Nathaniel Lichfield & Partners

On behalf of U and I Group PLC

Silvertown Tunnel DCO Hearing

Further Representations 16 February 2017

**PLAN**  
SCALE 1:250 @ A1

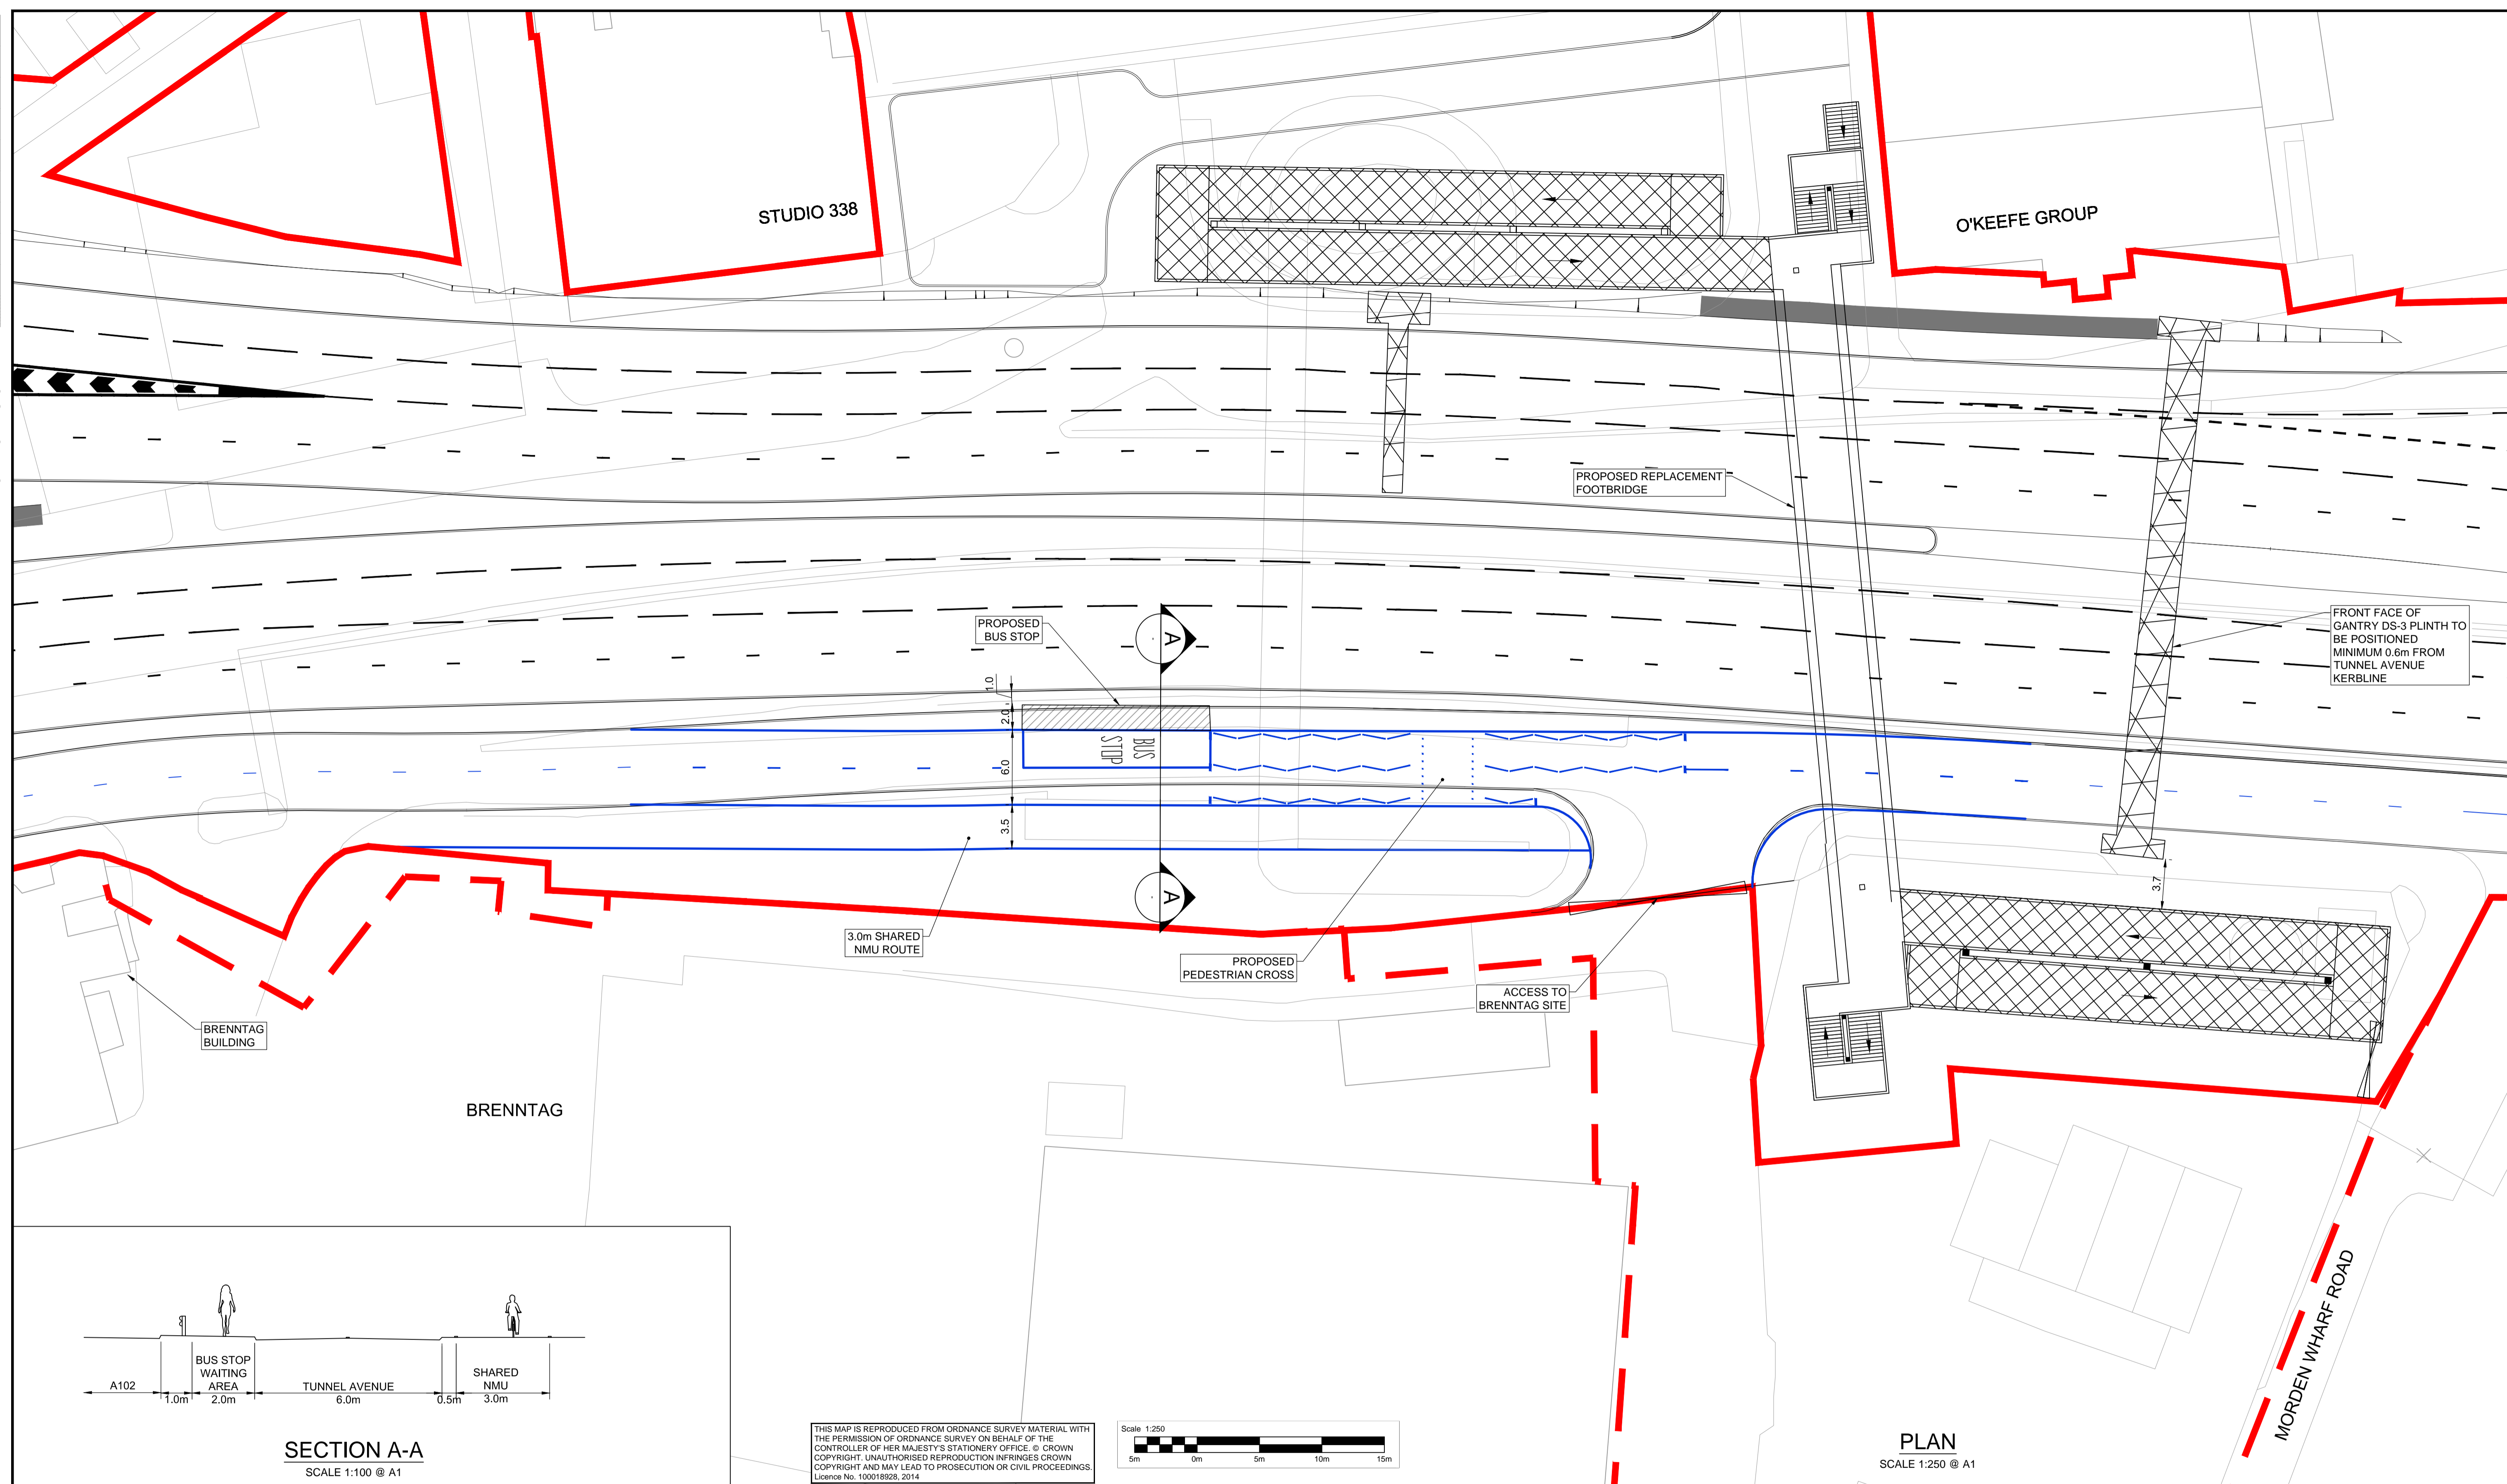
In parallel, the narrow width of the Tunnel Avenue would not allow for southbound bus passengers to descend from a bus onto a safe footway refuge before crossing Tunnel Avenue roadway to reach necessary destinations – including major schemes with both employment (Alcatel-Lucent and two safeguarded wharves) and residential (Enderby Wharf, Morden Wharf and The Telegraph Works) spaces.

When questioned during the conference call about likely solution options, Mr Beckett was clearly referring to a draft plan which showed the prospect of a local ‘chicane’ just north of the proposed new location for the western overbridge ramps, where a setback in the current Brenntag/highway boundary allows extra footway width. He indicated that this could allow a localised re-alignment of Tunnel Avenue to permit a bus stop pavement reserve on its eastern side (backing onto the main Tunnel Approach Road) to allow for passengers to wait for or descend from southbound bus services; the crossing to the full western footway was still likely to be uncontrolled. As noted above, this at-grade pedestrian crossing would be across a Tunnel Avenue with roughly doubled flows with increased HGV content.

We have not had sight of the draft drawing, which is apparently not to be released until D4 on 06 March. We confirmed that we would therefore be submitting further commentary in the short period between D4 and D5.
